23 October 2019

Name Jacob Vidler  
Address  
Address 47 Gallipoli Rd  
Coffs Harbour

**State Significant Development Application Number SSD-10300.**  
**Coffs Harbour Cultural and Civic Space.**

GORDON ST ELEVATION

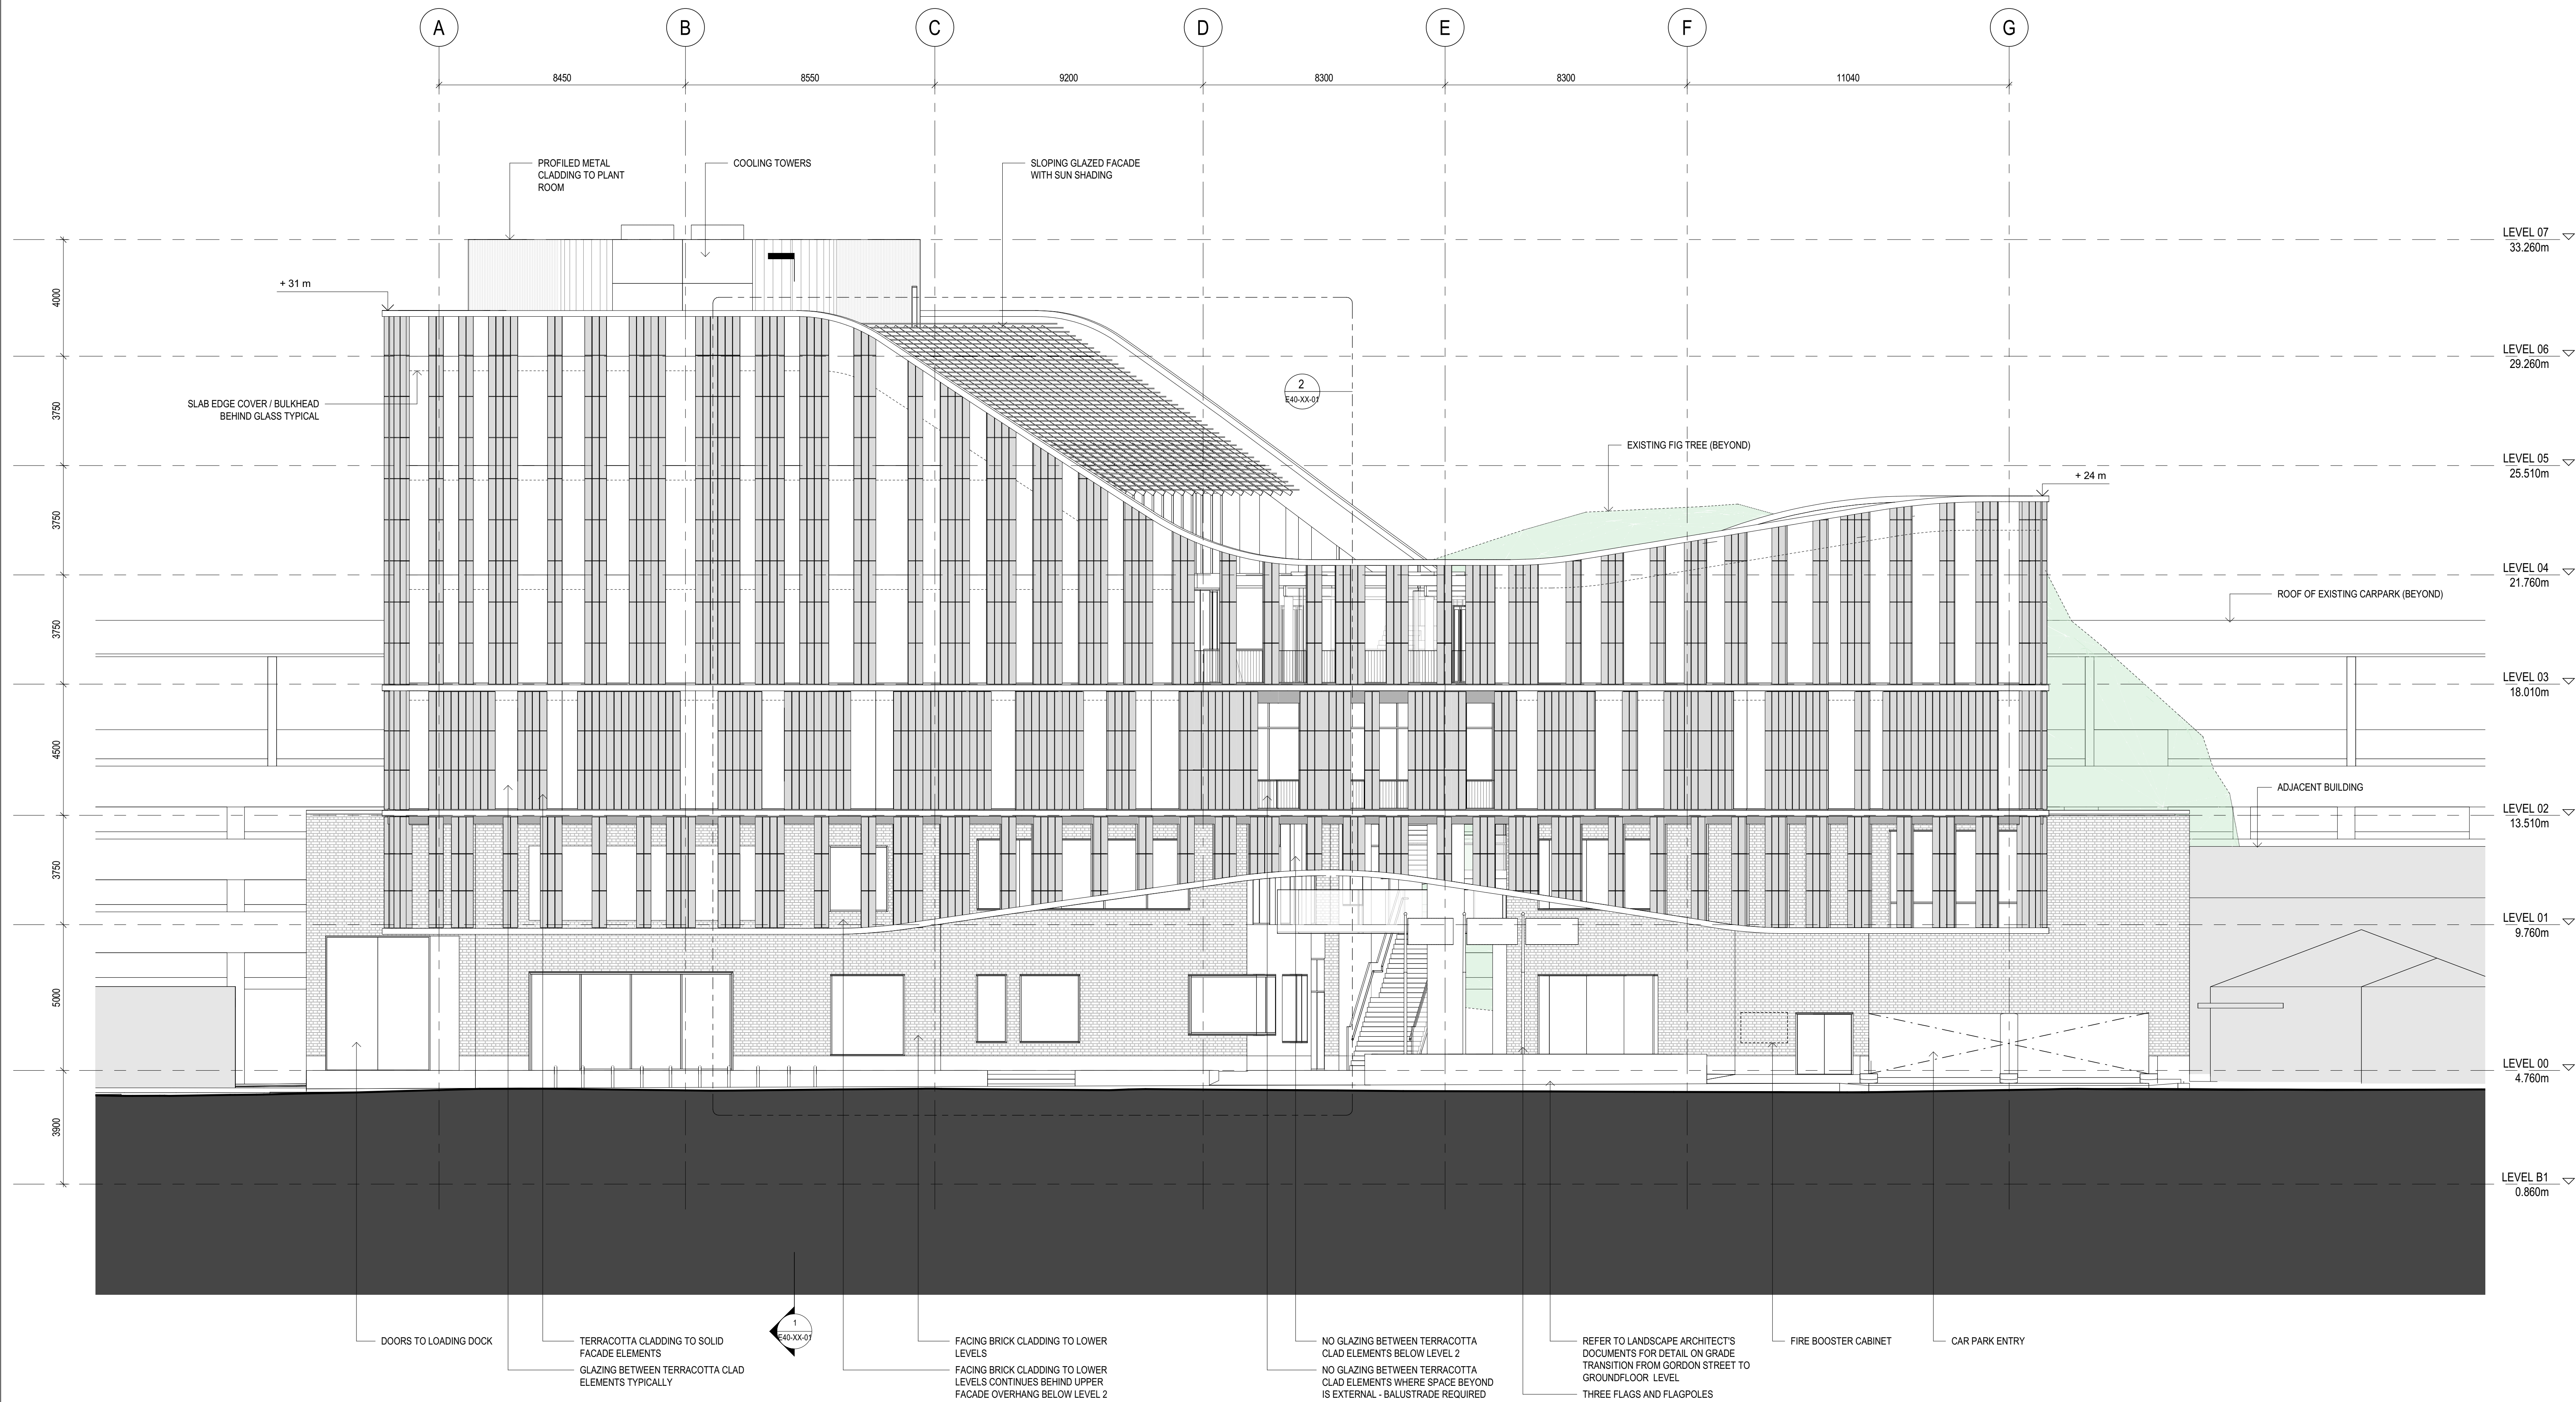
12. It conflicts with the streetscape in Gordon Street in that the proposed building is outside the context of this street having regard to the scale, existing street setbacks, design and general form of the adjoining buildings.

SECTION N-S

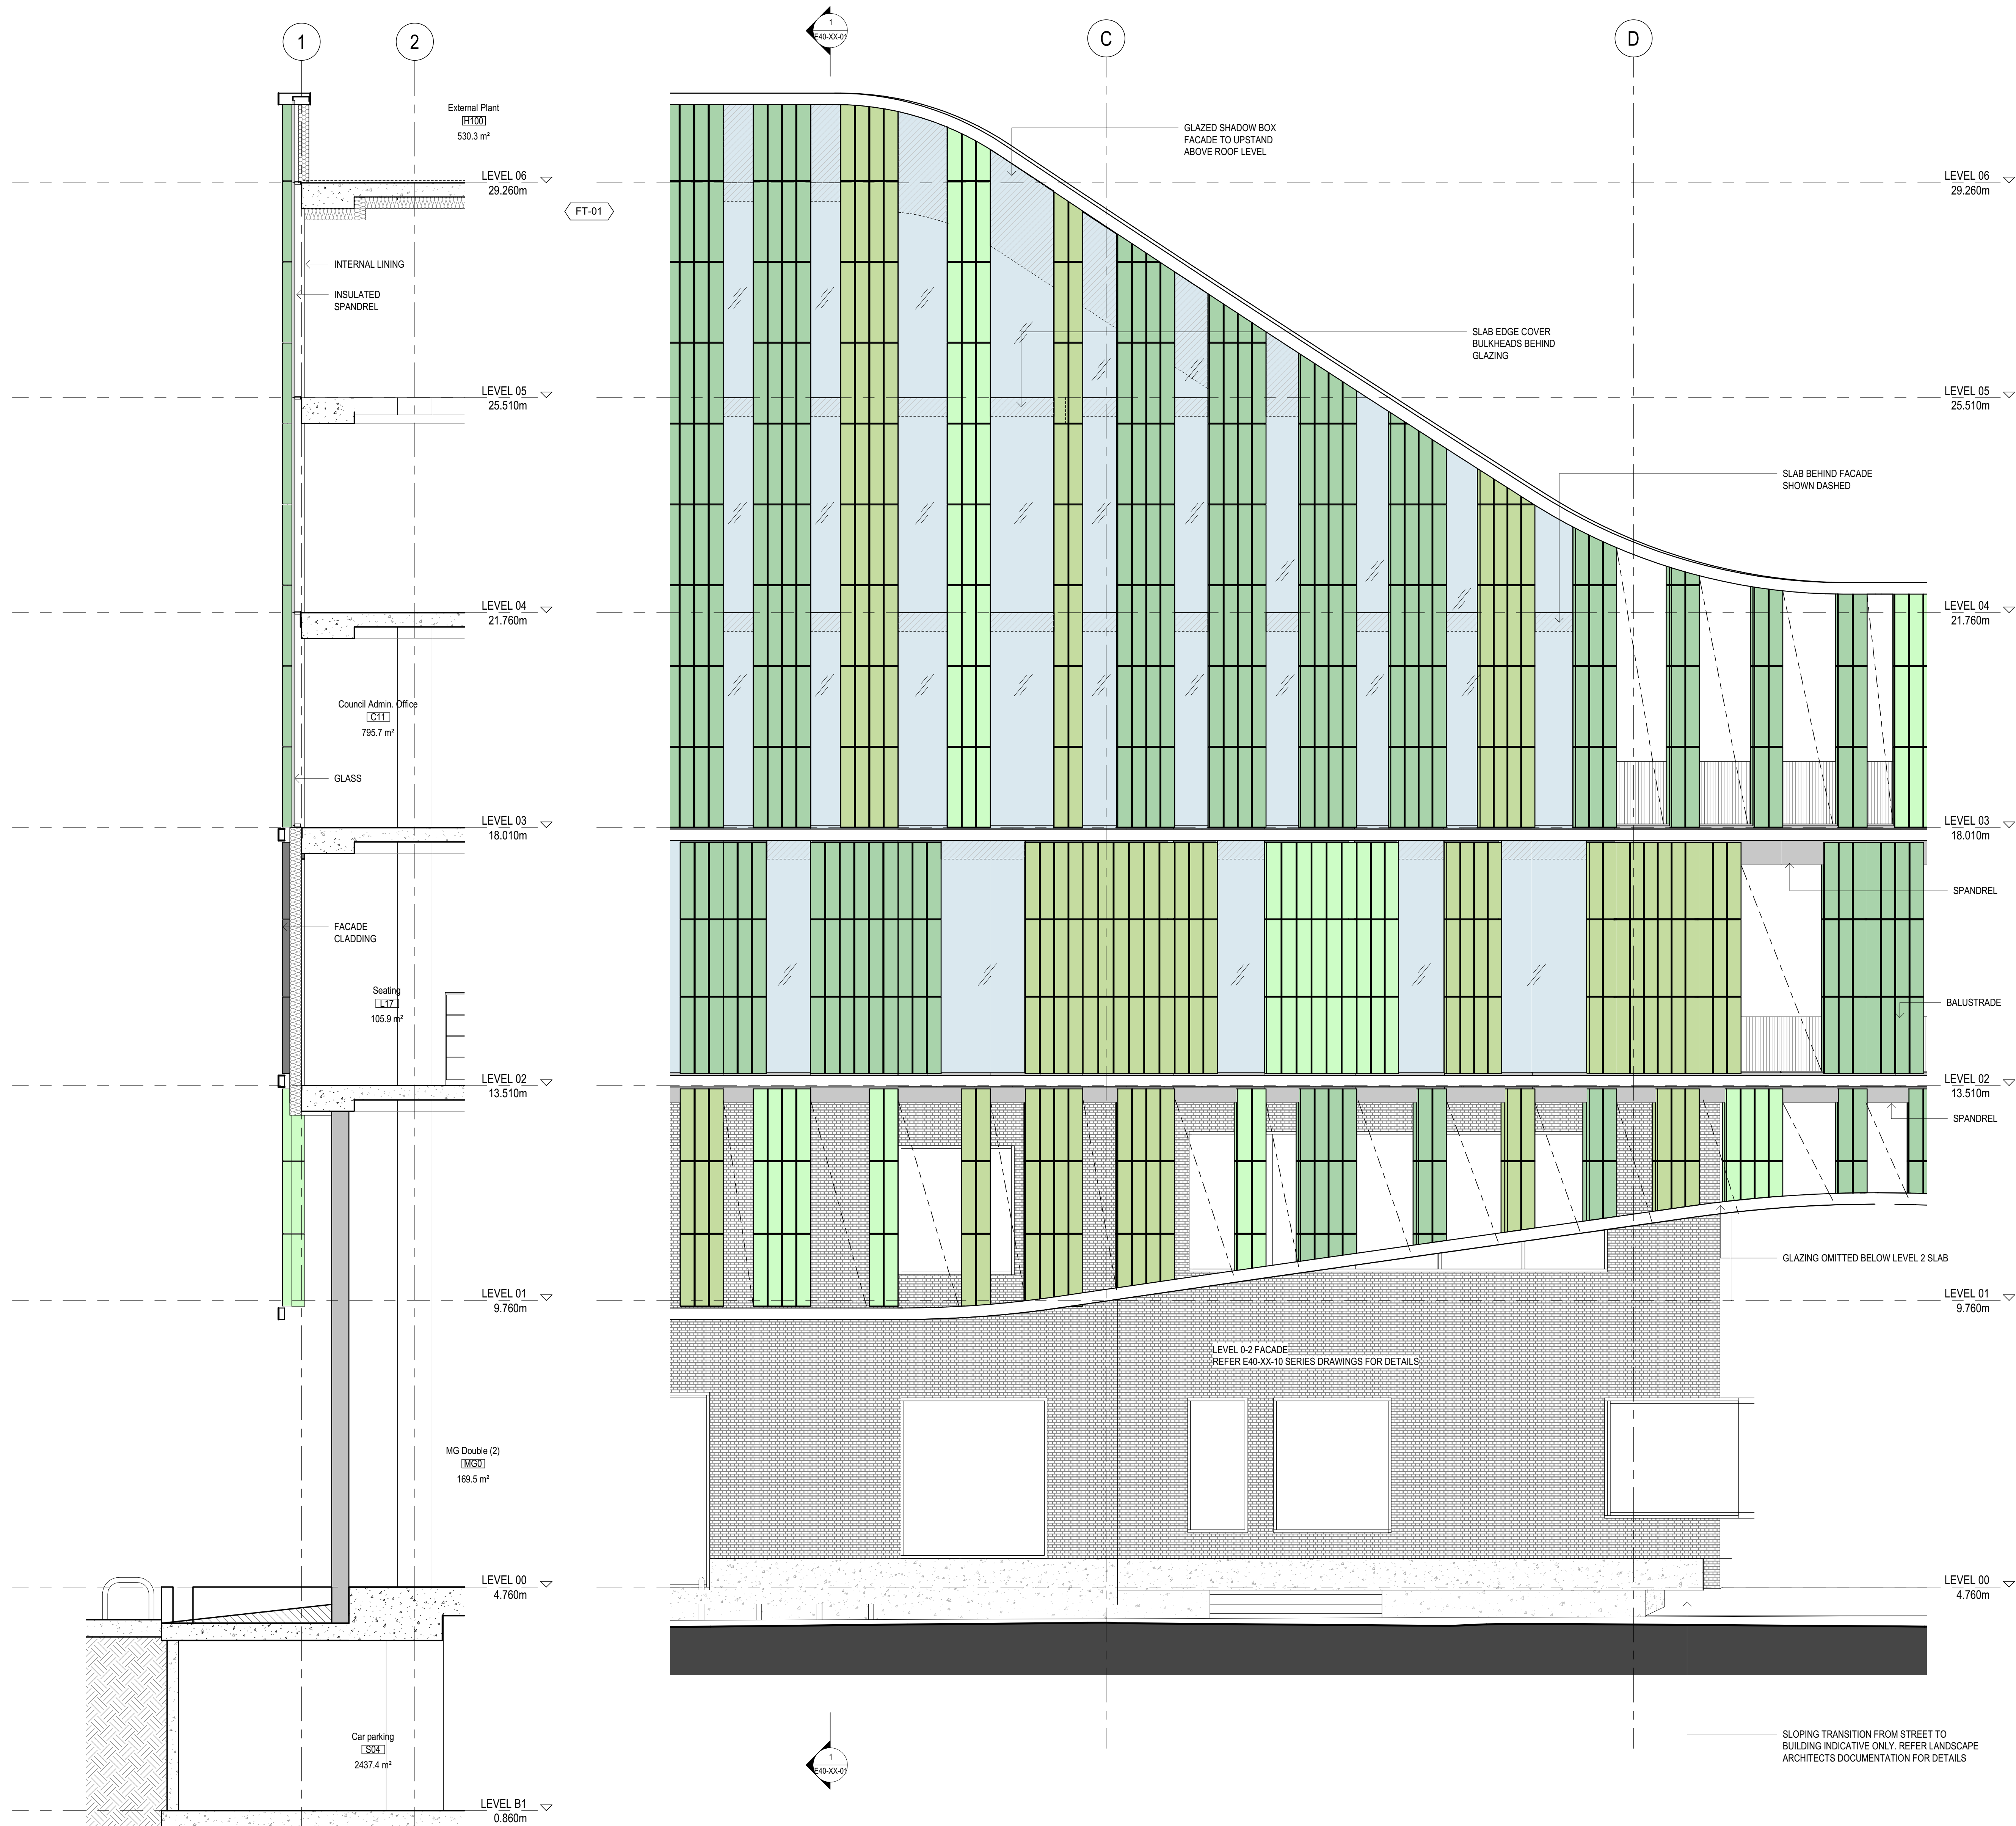
15. It exceeds the height limit of 28 m. set down by Council and an exception is not justified.
